Subject: AB/101/19/HH

AB/101/19/HH

The proposal is to remove the existing south facing living room window and install inward opening French doors. A galvanised and painted steel balcony will be fixed to the face of the building. The remaining living room window on the side (west) elevation and the two bedroom windows on the rear (south) elevation, will also be replaced.

First Floor Plan + Elevations
as Proposed

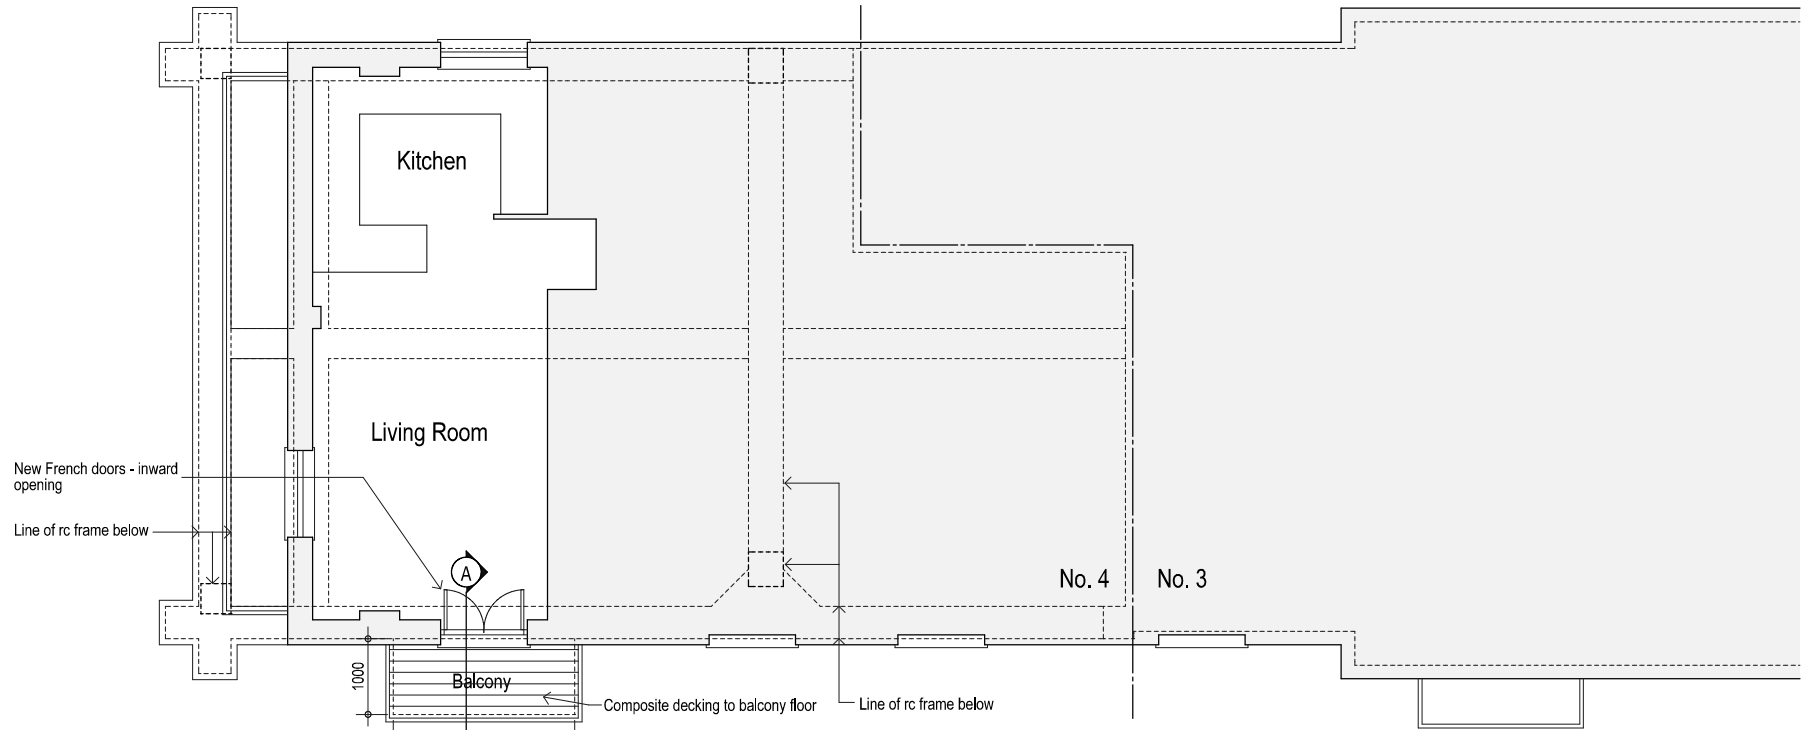
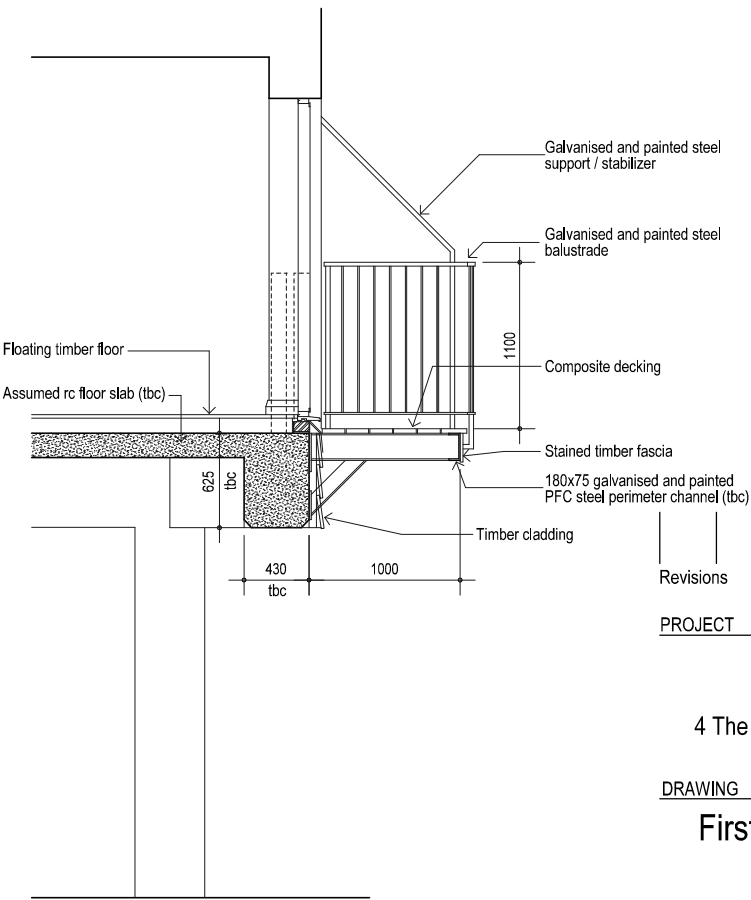
It is considered that the location of the proposed balcony, at the west end of the building, acts as a “bookend” to the balcony to the neighbouring flat, and thereby not harm the balance and symmetry of the elevation fronting on to the river.

The replacement windows and the new French Window should match the existing joinery in terms of appearance, and it would appear from the submitted information that this would be the case.
